From: Zac Denton <Zac.Denton@arun.gov.uk>
Sent: 17 June 2020 14:34
To: Planning Scanning <Planning.Scanning@arun.gov.uk>
Subject: FW: Smugglers - R/62/20/HH - Revised Garage design

183038/ 07

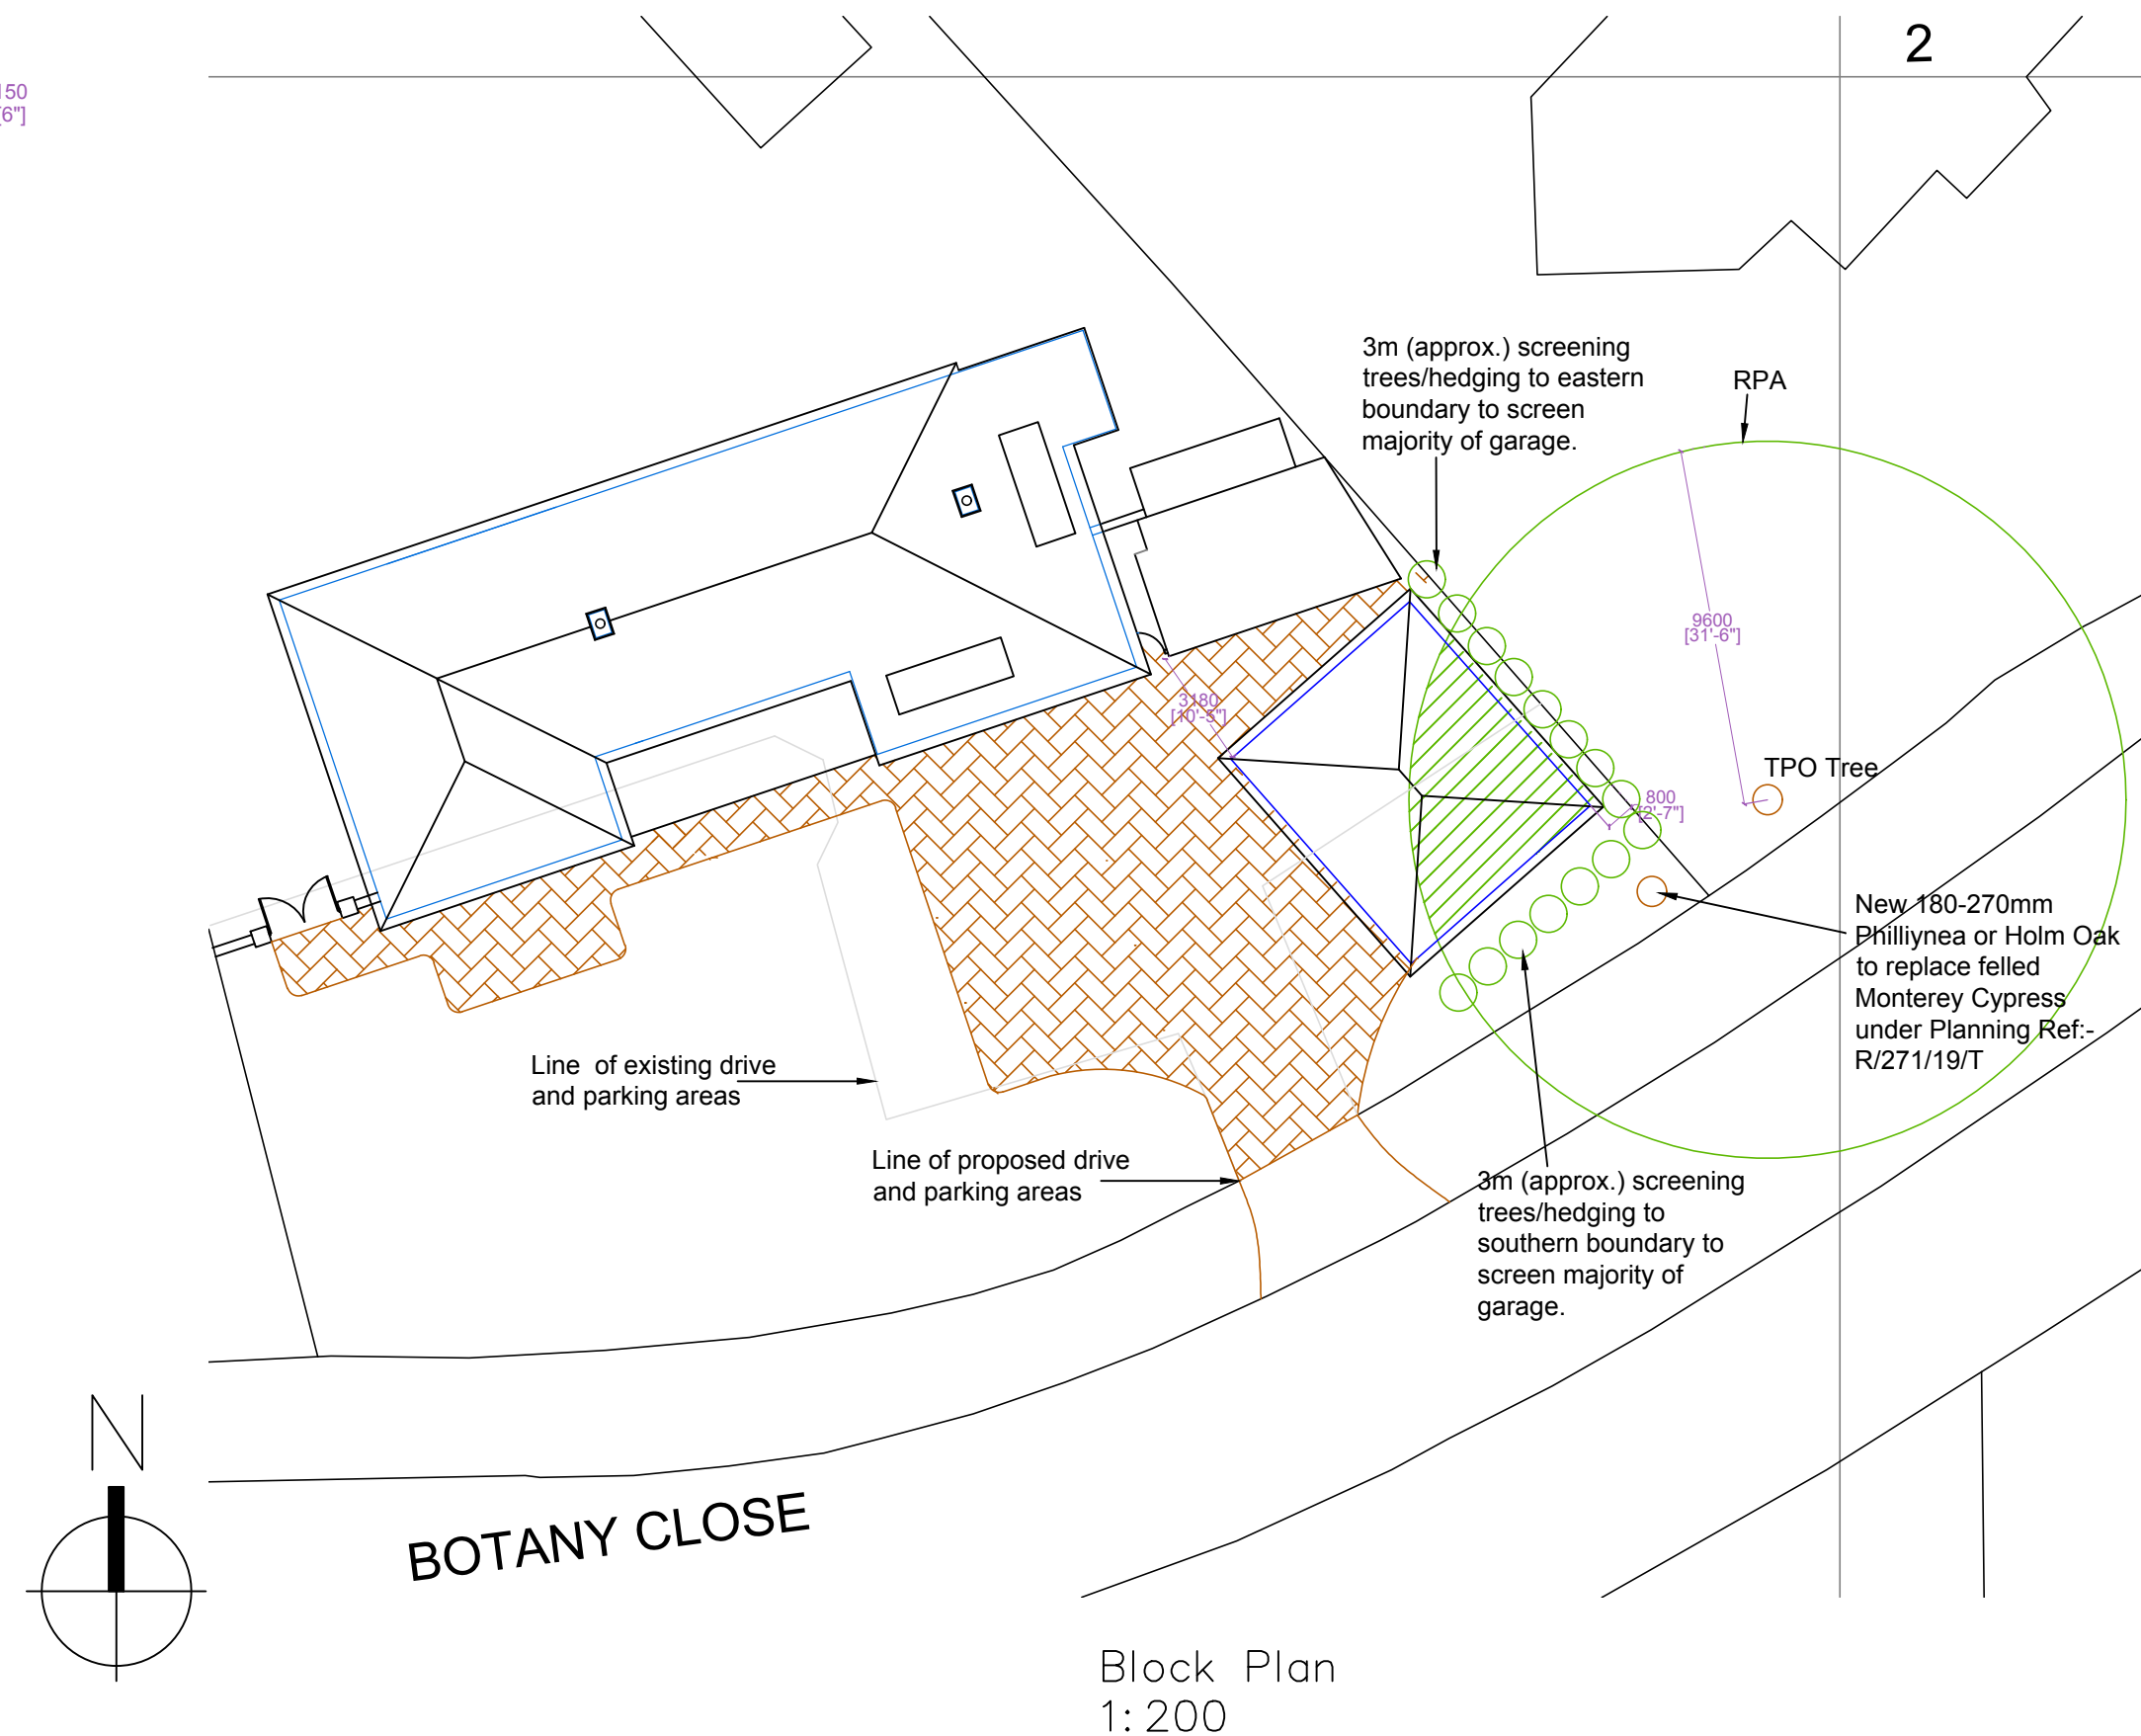
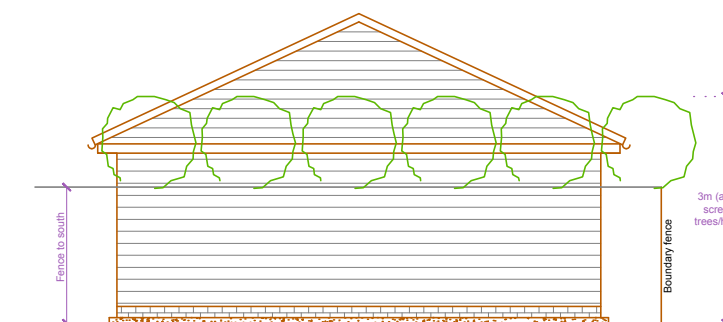
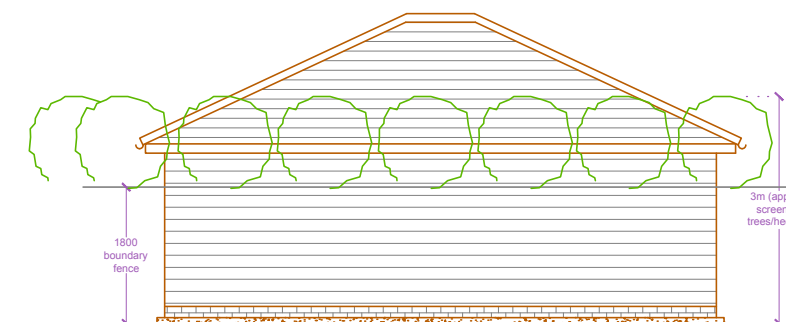
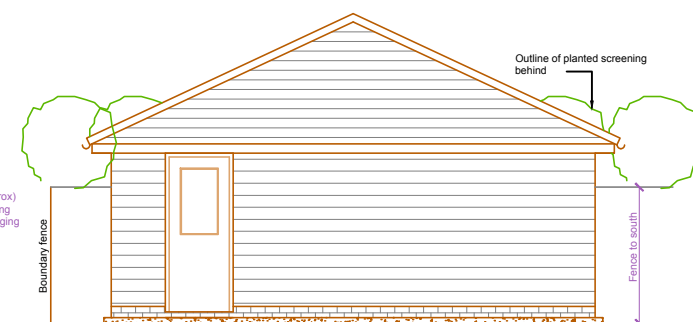
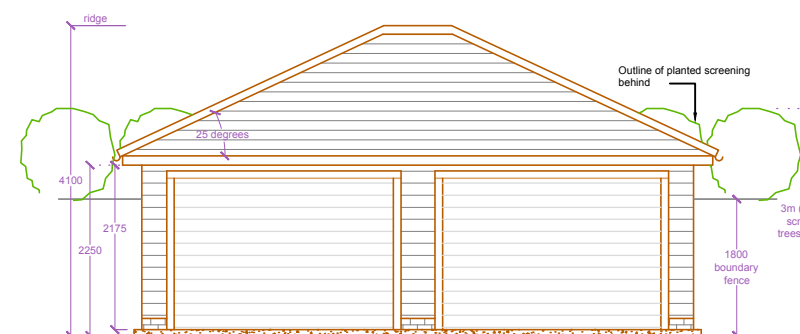
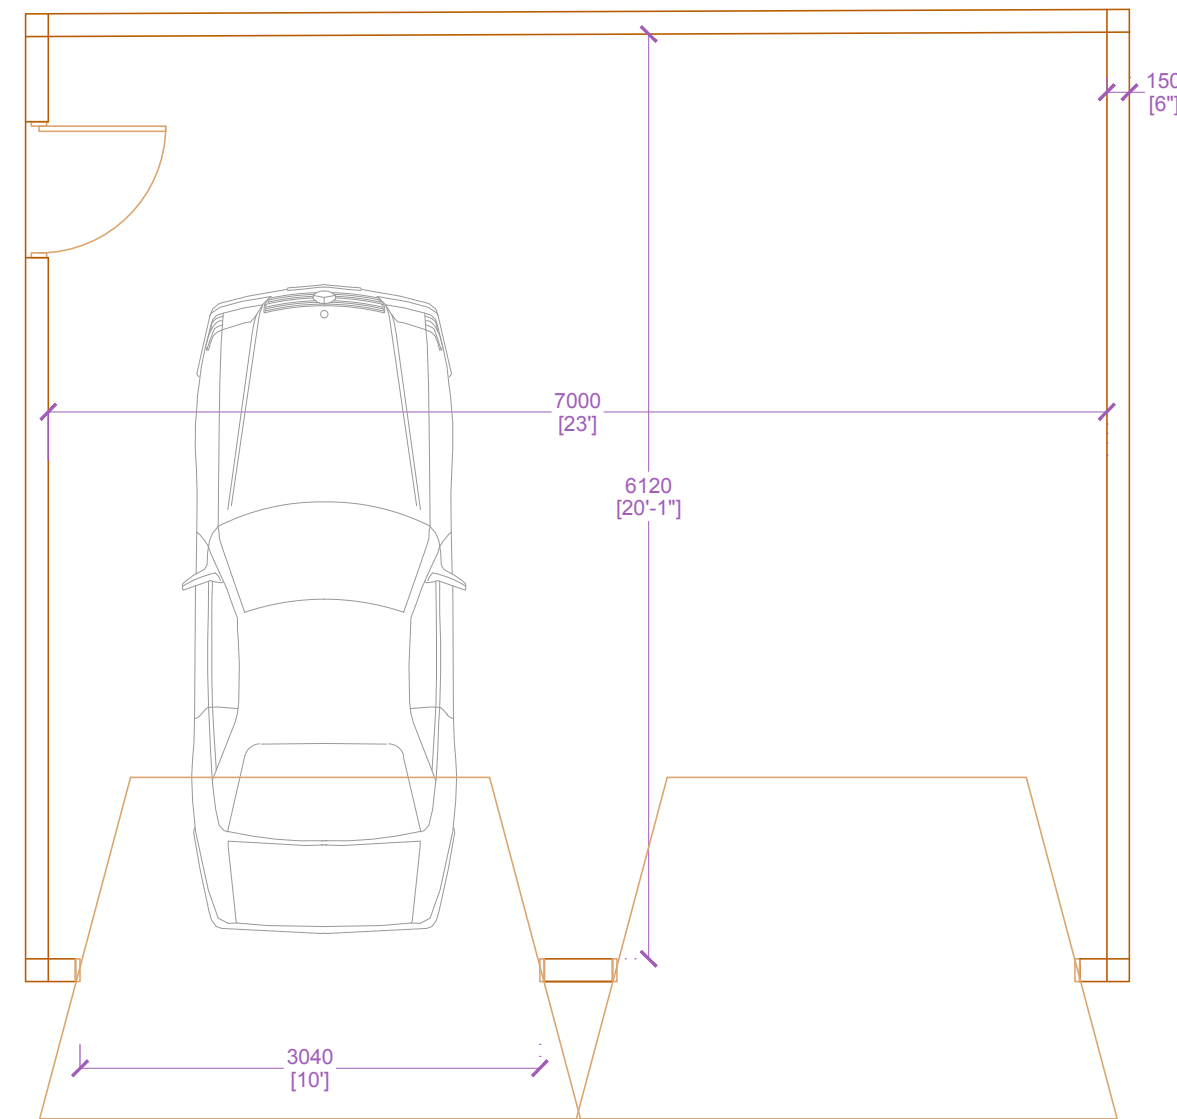
Please could you confirm if now that the garage is to be visually screened by the trees if a brick wall material would be acceptable? Our client is keen for the materials to match where possible.

Yes, that is the level of landscaping detail we would be requiring. Additionally, if material details can be specified on the plans, this would be preferable.

Please note that due to the sensitivity of the application, we would be looking for landscaping details to be submitted prior to decision.

- 1) The pitch of the roof has been reduced resulting in a reduction in the ridge height and overall mass of the roof.
- 2) The proposed materials have been varied from facing brick and interlocking tiles to match the house, to softwood featheredge weatherboard and brown plain clay tiles, to more subtly blend visually with the surroundings.
- 3) Landscaping to the South and Eastern boundaries has been added to screen the majority of the garage, which now sits more sympathetically within the streetscape.

I have spoken with my Team Leader and we are happy to go forward with the scheme as you have proposed it in the attached plan.
